**Consultation Response from KC,
Conservation & Design**

2025/90549 78, John William Street, Huddersfield, HD1 1EH

**Listed Building Consent for change of use and alterations to convert offices to 14 apartments
(use class C3) (within a Conservation Area)**

Date Responded: 18/7/25

Windows

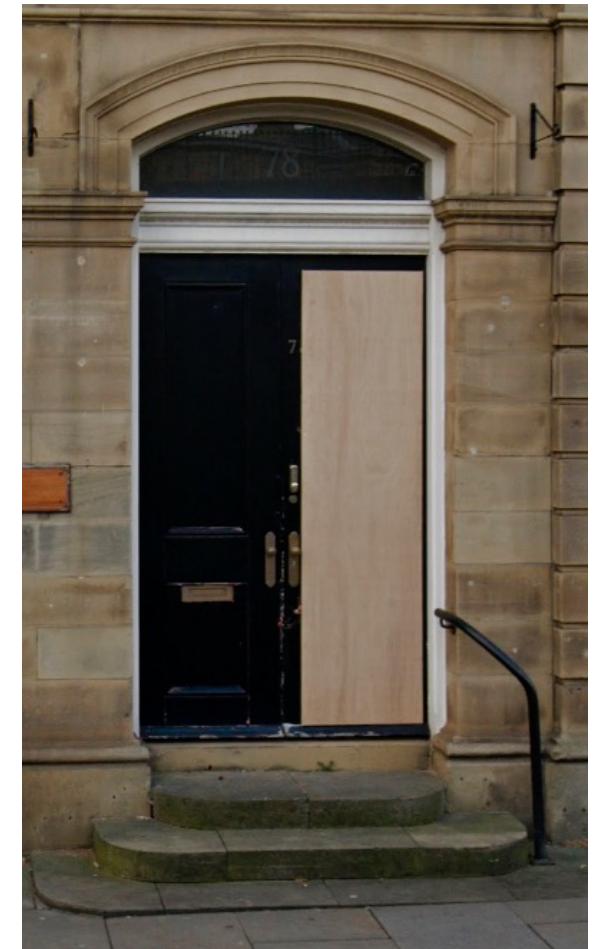
The applicant should confirm if any secondary glazing is proposed, and try to design it to fit the pattern of the existing timber windows where possible.
